2023/0959

Change of use of first floor to Shisha Bar/restaurant and associated external alterations including first floor balcony to front, roof terrace above second floor, fire escape staircase to side, glass parapet means of enclosure, second floor extension to side for storage purposes and lift shaft to side (re-submission of 2022/0555)

The Mill, 10 Lower Castlereagh Street, Barnsley, S70 1AR

Drawing Title **PROPOSED PLANS**

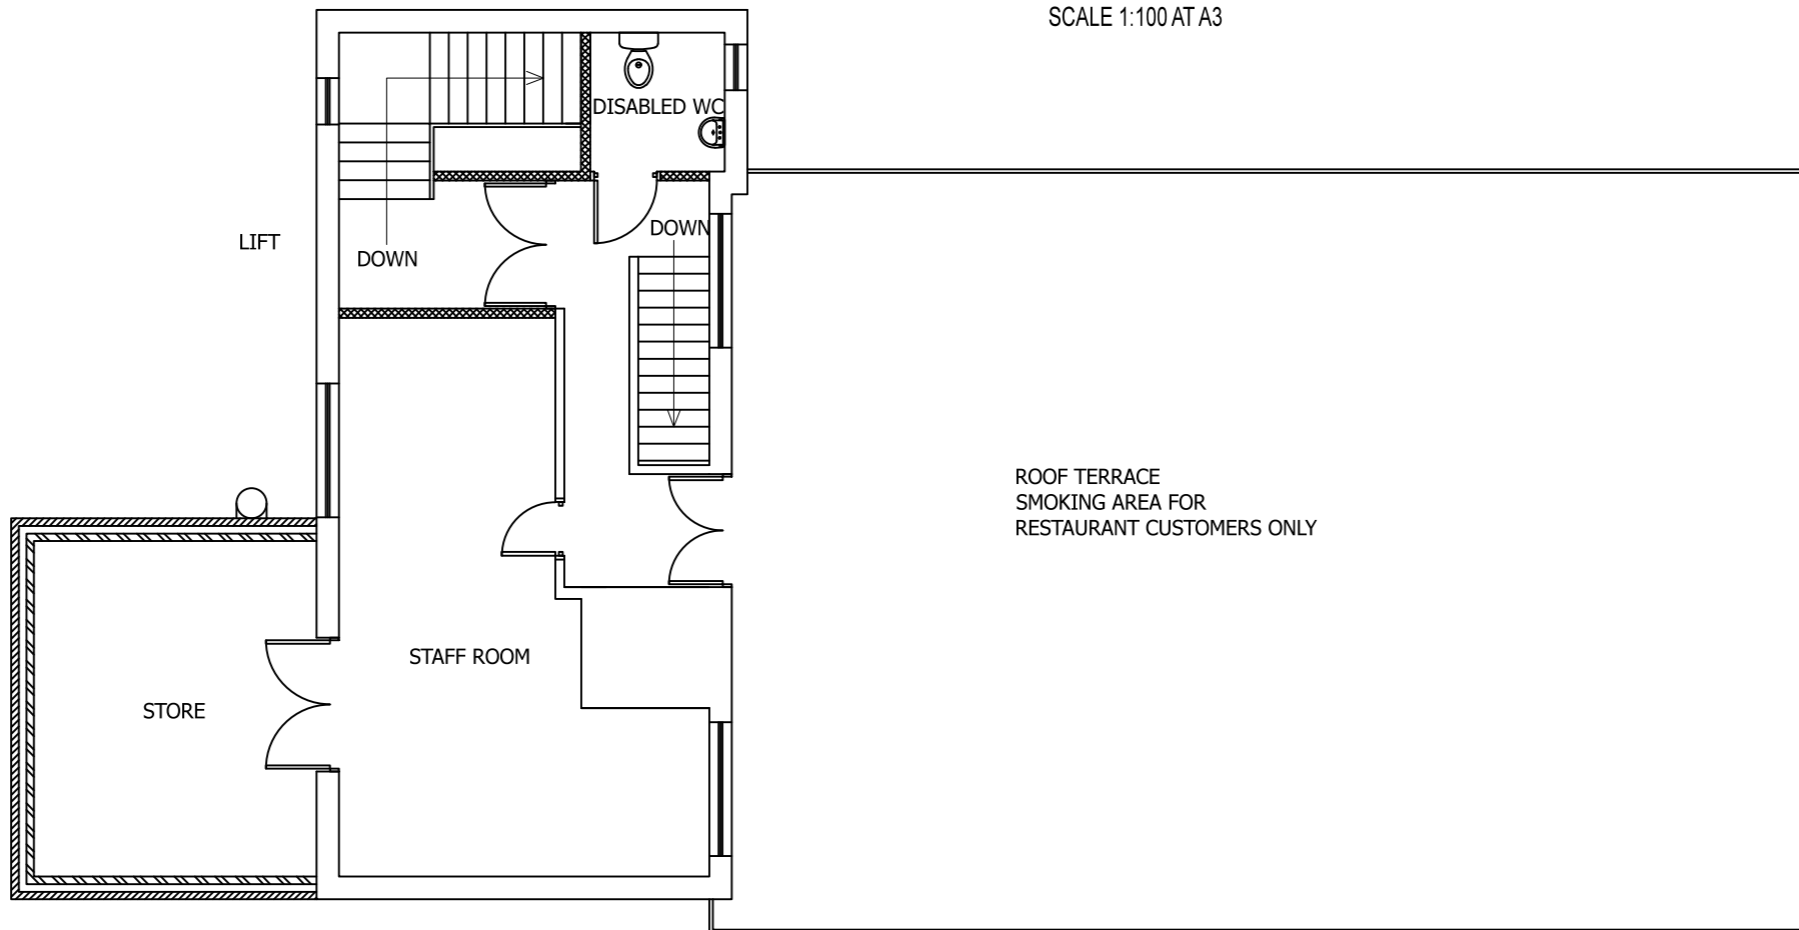
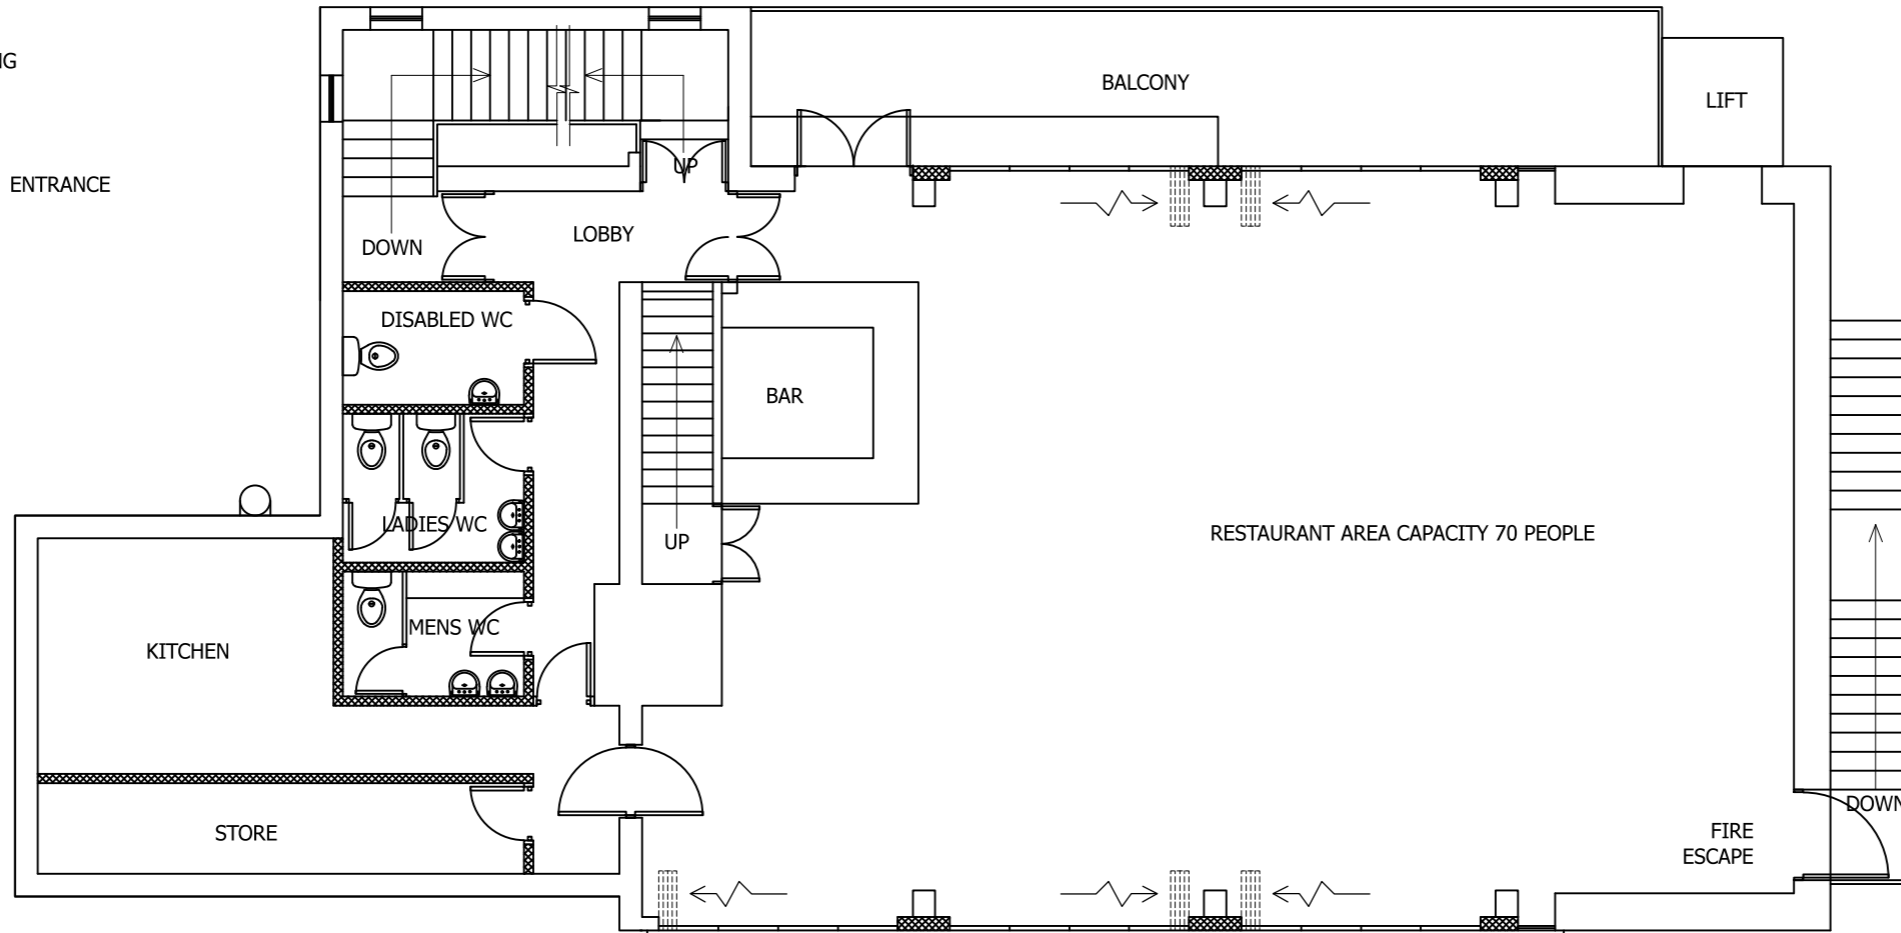
The applicant has agreed to the use of prison weldmesh to be integrated into the gaps of the external staircase to reduce the risk of accident or worse, reflecting the advice of the Police on a previous similar application on the site. This product is not dissimilar to mesh fencing and design advice has previously been that it is considered acceptable in appearance subject to details of how it will be integrated into the gaps in the staircase. A condition is recommended accordingly, together with a further condition requiring details of a fire exit door to prevent access to the stairwell, in the interests of the satisfactory appearance and safety of the completed development

Drawing Title **PROPOSED ELEVATIONS 1**

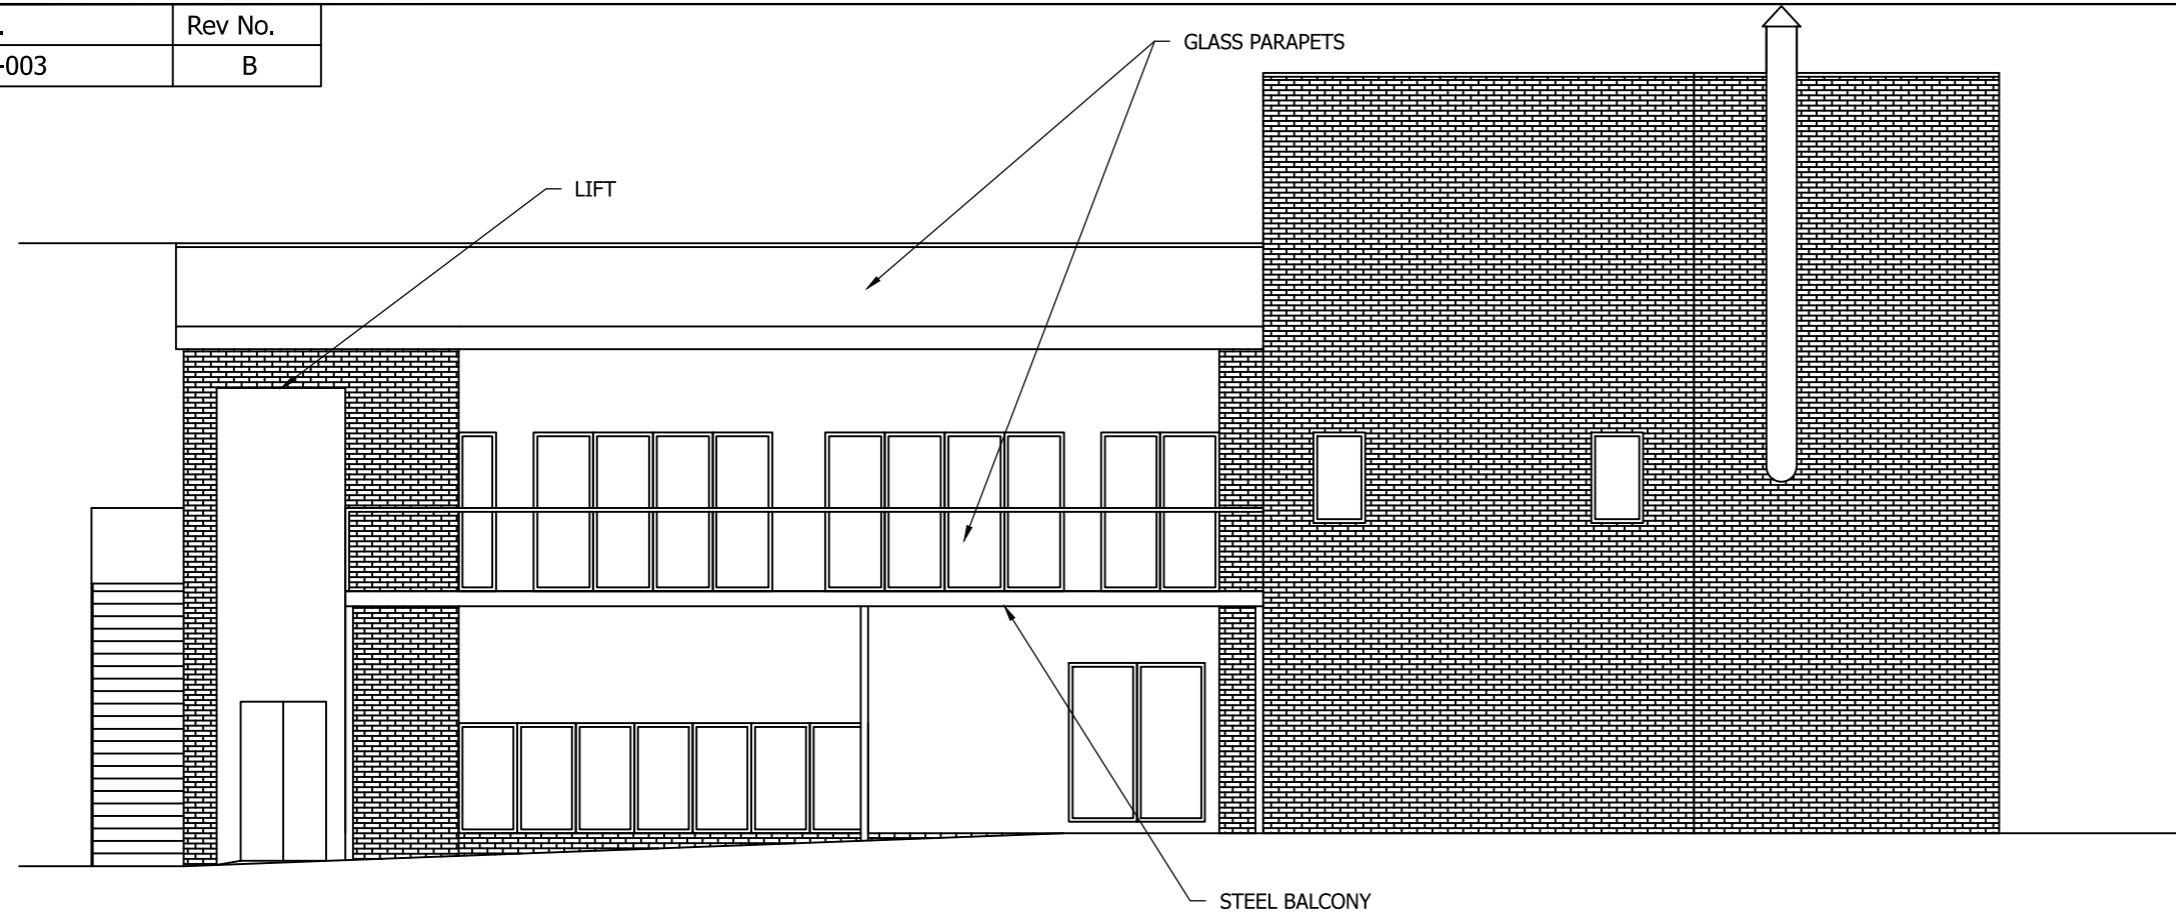
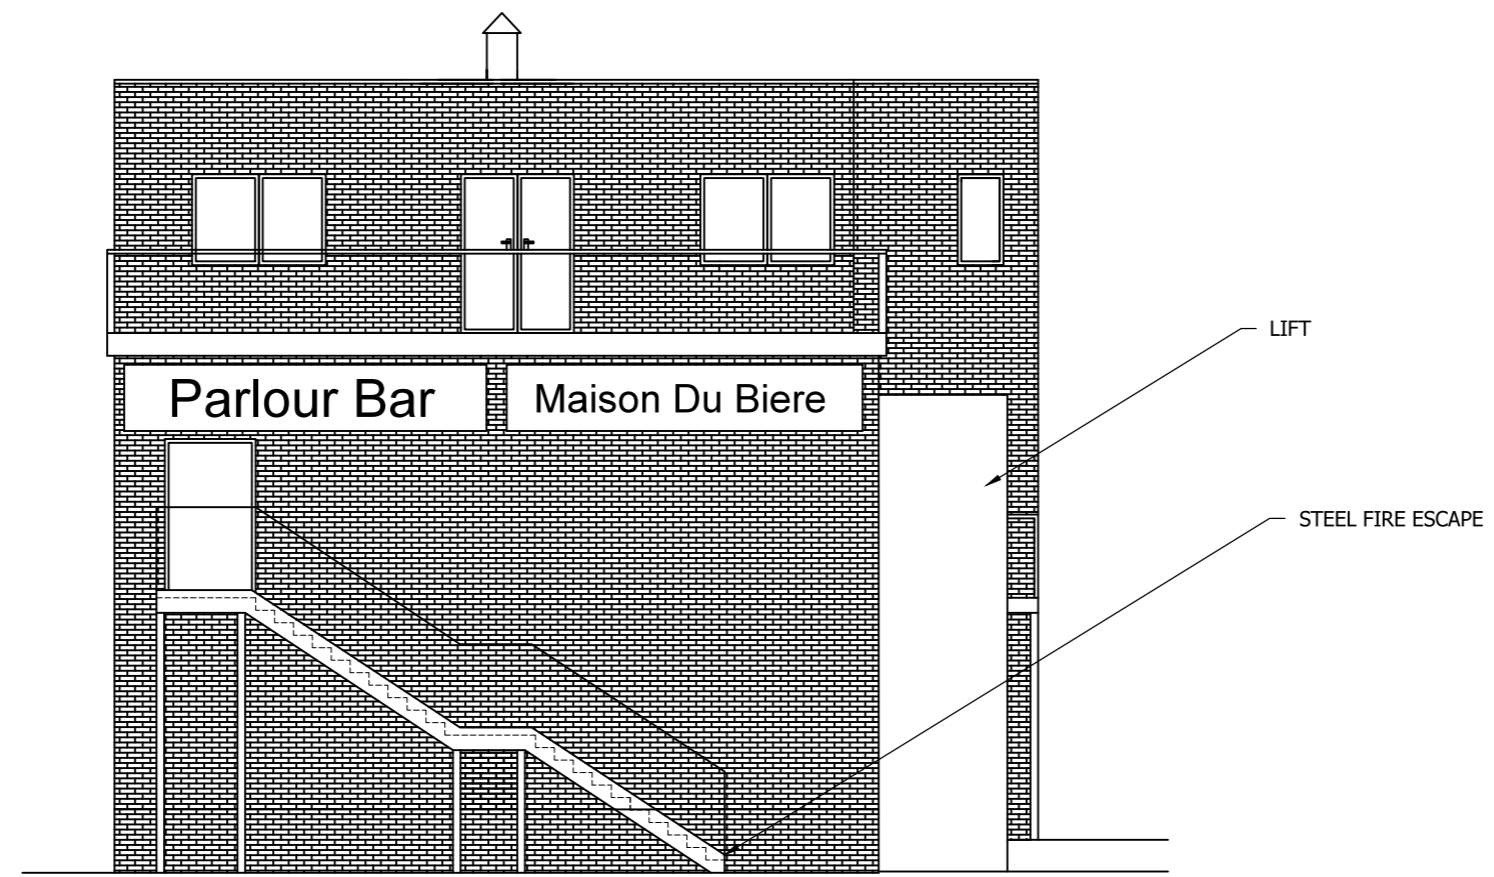
Conservation – This resubmission involves a variation of the approved scheme that includes moving the lift shaft from the northwest to the northeastern (principal) elevation and away from the setting of the Wesleyan Reform Church on Blucher Street. This is positive and no objections are raised in principle, provided that the matching bricks are used in the lift shaft as previously approved and the mechanical extraction flue is finished matt black.
